City of Portland, Maine - Building or Use Permit Application

Permit No: 02-0997	Issue Date: Sept 18 2002	CBL: 389 B009001
-----------------------	-----------------------------	---------------------

Location of Construction: 104 Carter St	Owner Name: Thomas Timothy A &	Owner Address: 104 Carter St	Phone: 207-797-0721
Business Name:	Contractor Name: Applicant	Contractor Address: Portland	Phone:
Lessee/Buyer's Name	Phone:	Permit Type: Additions - Dwellings	Zone: R-2

Proposed Project Description: Construct a 22' x 22' addition	FIRE DEPT: <input type="checkbox"/> Approved <input type="checkbox"/> Denied <i>N/A</i>	INSPECTION: Use Group: R-3 Type: SB BOCA 99 <i>JA</i>
---	--	--

New Addition BUILDING Diagram

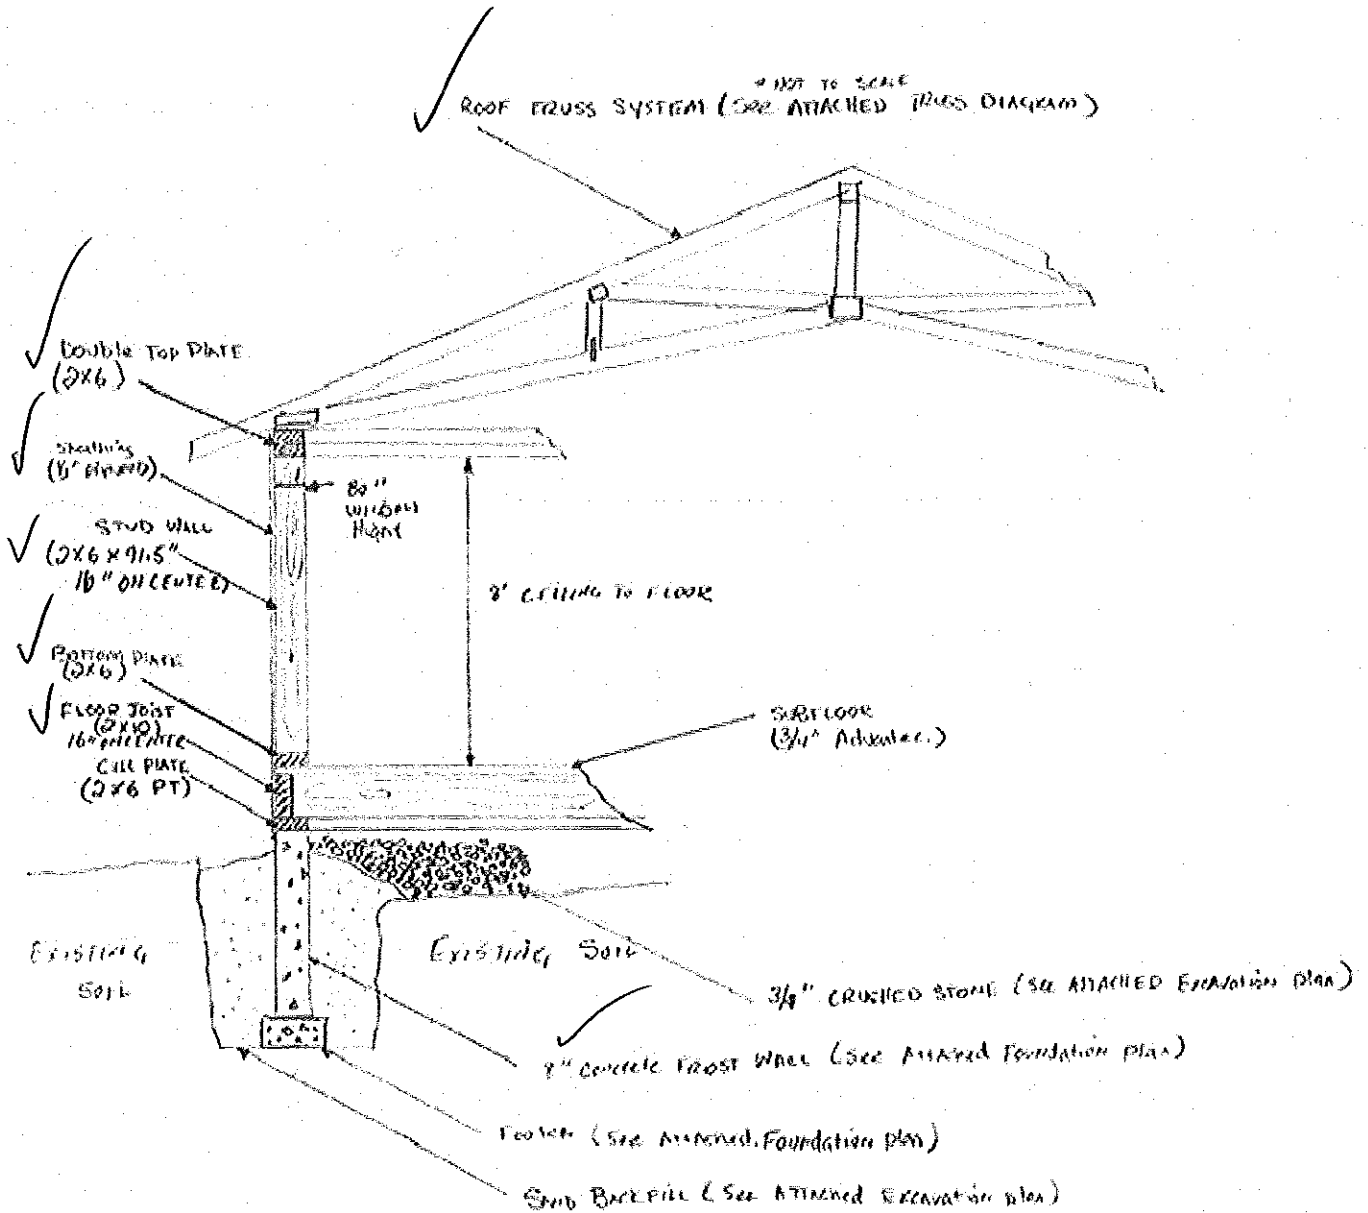
You must have an 18"x 24" minimum access opening to crawl space.

Comment Date	Comment	Name	Follow Up Date	Completed
09/11/2002	Spoke w/owner - went over everything needed. She said she'd submit tomorrow.	imm		<input type="checkbox"/>
09/11/2002	No dimensions on plot plan - inadequate structural plans. Called owner.	imm		<input type="checkbox"/>
09/17/2002	rec'd all info requested - ok to issue.	imm		<input type="checkbox"/>

✓ Window headers: (3) laminated 2" x 8" wood beams over every window and door for support.

✓ Floor support: (3) laminated 2" x 10" wood beams supported by foundation; runs side to side. Beam to be supported by (2) lolly columns every 7' on center. Lolly columns will be supported by cement footers.

* A 22' x 22' wood structure addition connecting to existing home. Addition will be supported by 4' frost wall foundation.

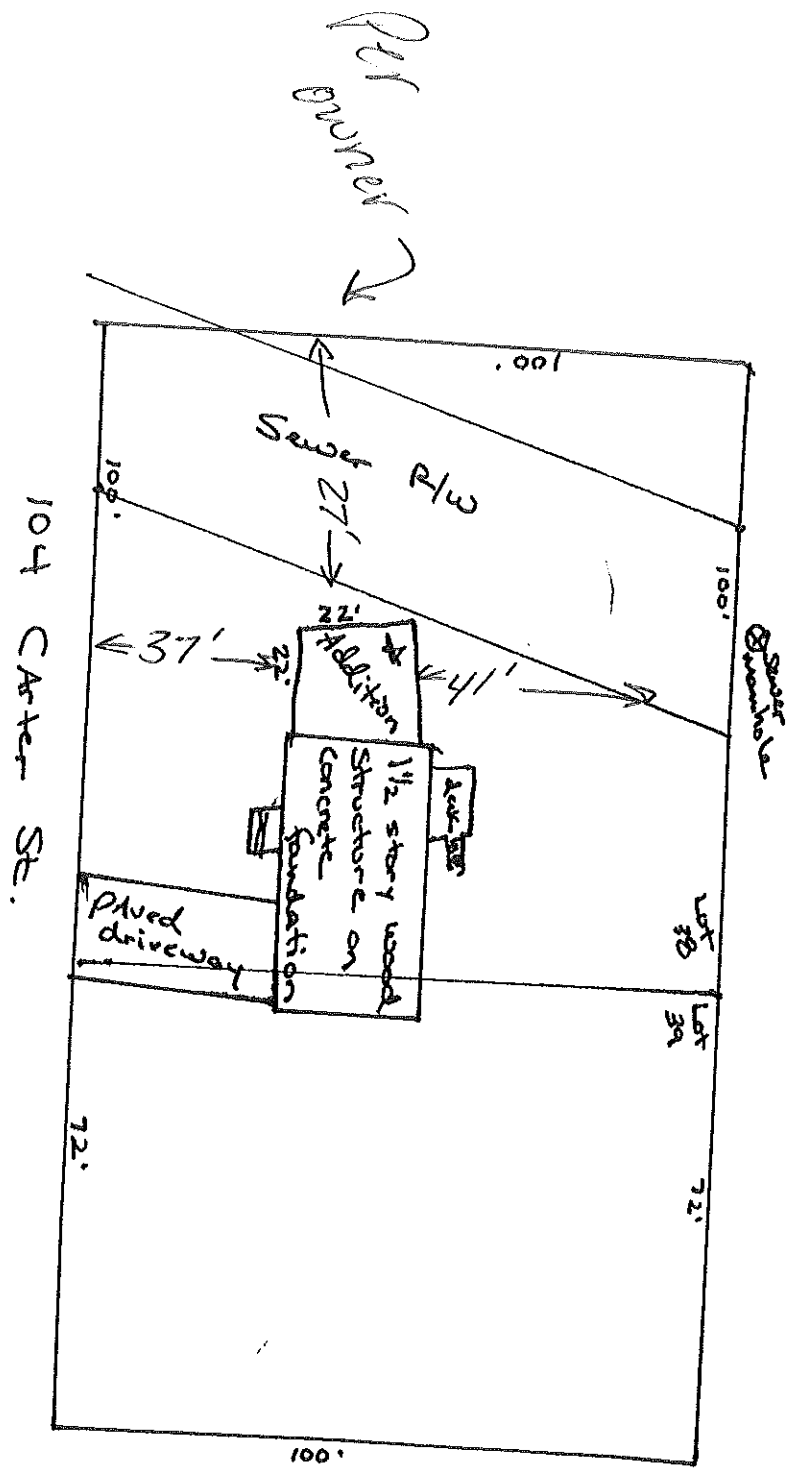
The frost wall must be minimum 4'-0" below grade.

* A 22' x 22' wood structure addition connecting to existing home. Addition will be supported by 4' frost wall foundation.

Front: 37'
Side: 27'
Back: 41'
